**Transport
for NSW**

**Exhibition of Modification Request for Wollongong Hospital Development
(MP 10_0213 MOD 1)**

TfNSW has reviewed *Traffic Impact Assessment, Wollongong Hospital*, June 2013 prepared by CARDNO for NSW Health Infrastructure.

Figure 4: Proposed Level 5 layout

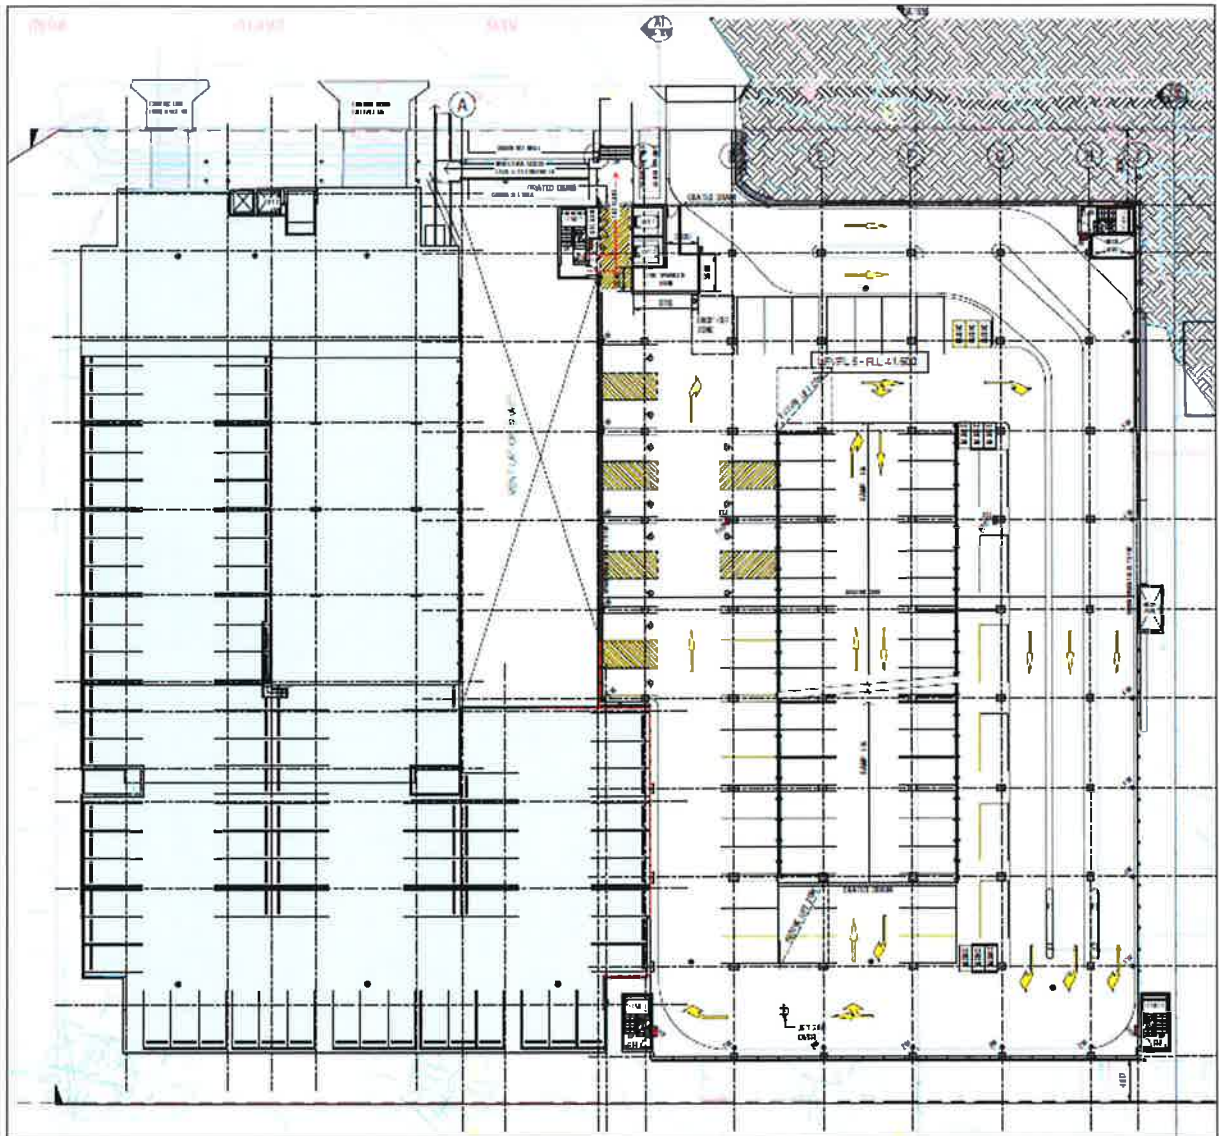
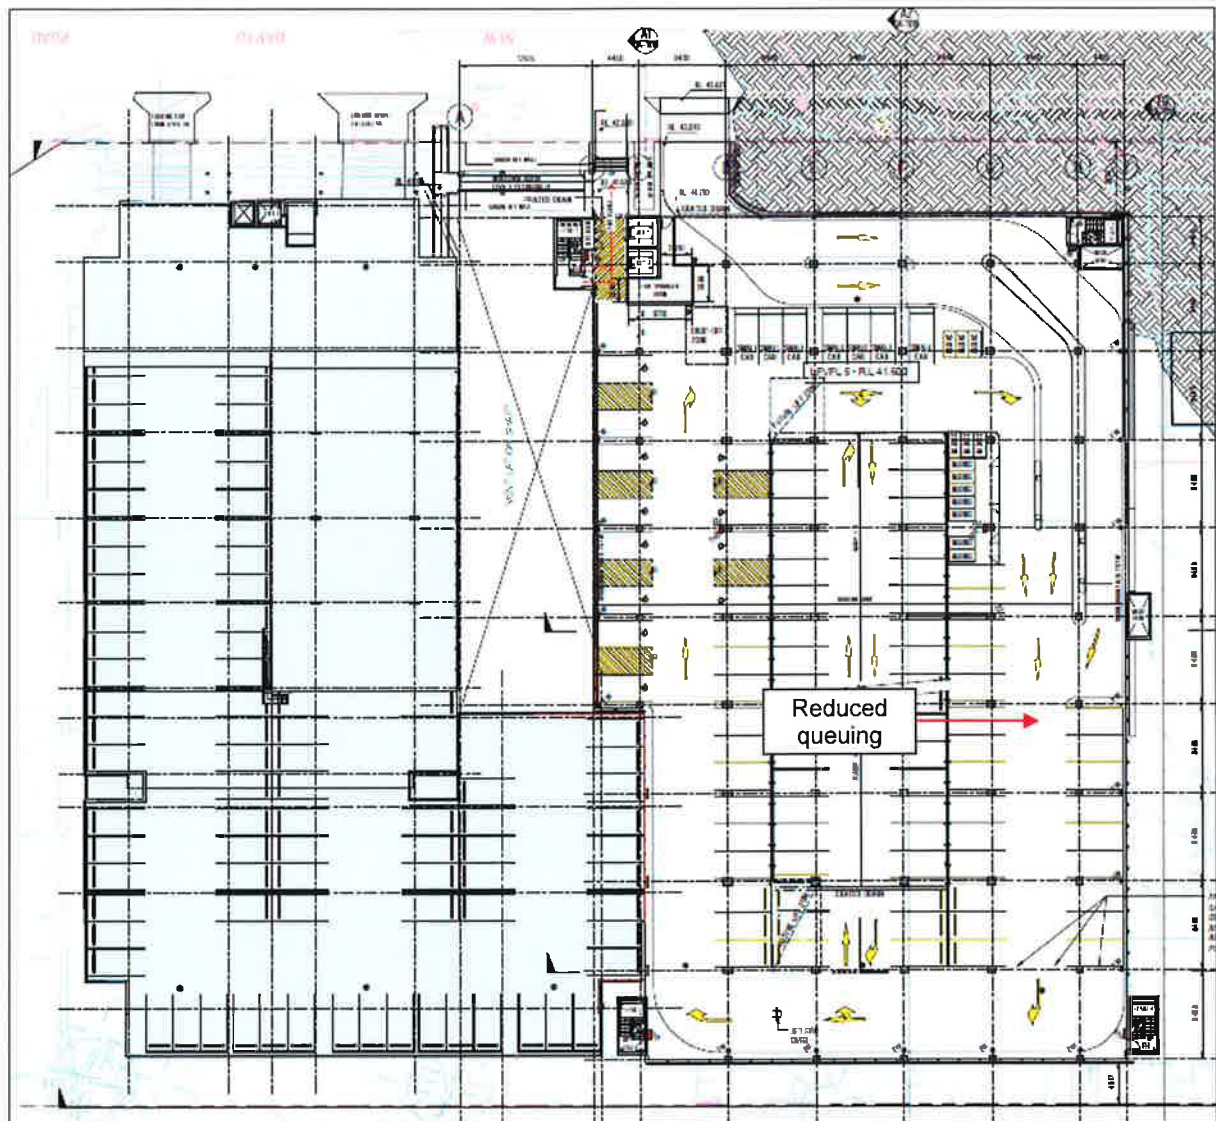
- The traffic impact assessment undertaken by CARDNO has not assessed the potential impacts to the current and future bus network within the vicinity of the car park site, in particular bus services operating on Crown Street and New Dapto Road. TfNSW advises that:

Due to the high level of bus services currently operating along Crown Street and New Dapto Road, TfNSW recommends that mitigation measures be developed by Health Infrastructure in consultation with TfNSW/RMS to minimise impacts on bus services in the vicinity of the hospital site.

TfNSW/RMS is concerned with the performance of the junction of Crown Street (HW1) and New Dapto Road. TfNSW/RMS would like to work with Health Infrastructure to minimise the impact on the surrounding network due to the proposed development (a 754 space car park) due to the following reasons:

- Based on the traffic flow diagrams shown in Appendix D of the Traffic Impact Assessment, the modification will result in a 31% and 23% increase turning traffic in AM and PM peak periods respectively at the junction of Crown Street and New Dapto Road (from 2016 background + development to 2016 background + development + car park). This is a significant increase.

- The traffic volumes used in the SIDRA analysis appear to correlate with the increases shown in Appendix D of the traffic impact report. However, based on the results of the SIDRA modelling provided in the Appendices of the traffic impact report, TfNSW/RMS notes that the PM peak the average delays for right turning vehicle from New Dapto Road onto Crown Street increase substantially during the PM peak period in 2026 with the proposed car park in place. Traffic signal optimisation has been recommended in the traffic impact report as a measure to reduce overall intersection delay at the Crown Street/New Dapto Road intersection. However, the proposed optimisation increases delays significantly for through movements on the State road (Crown Street) whilst the average delay for the right turn movement from New Dapto Road to Crown Street reduces significantly (despite the additional traffic). TfNSW/RMS considers that it is inappropriate to compromise the operation of the State Road in this manner. TfNSW/RMS recommends that the impacts of the development be mitigated by road infrastructure upgrades.

- Based on the SIDRA results for the Crown Street/New Dapto Road intersection provided Appendices of the traffic impact assessment, Level of Service (LOS) for the New Dapto Road approach is predicted to improve with the development traffic from F (for the 2016 the baseline scenario) to LOS D (for the 2016 baseline + development scenario) during the afternoon peak period. This is unlikely to occur without infrastructure improvements/traffic signal optimisation for the Crown Street/New Dapto Road intersection.

Based on the above, TfNSW/RMS requests that a thorough review of traffic assessment methodology and traffic models be undertaken by RMS. TfNSW recommends that feasible mitigation measures be developed by Health Infrastructure in consultation with TfNSW/RMS to minimise the impacts on the road network.
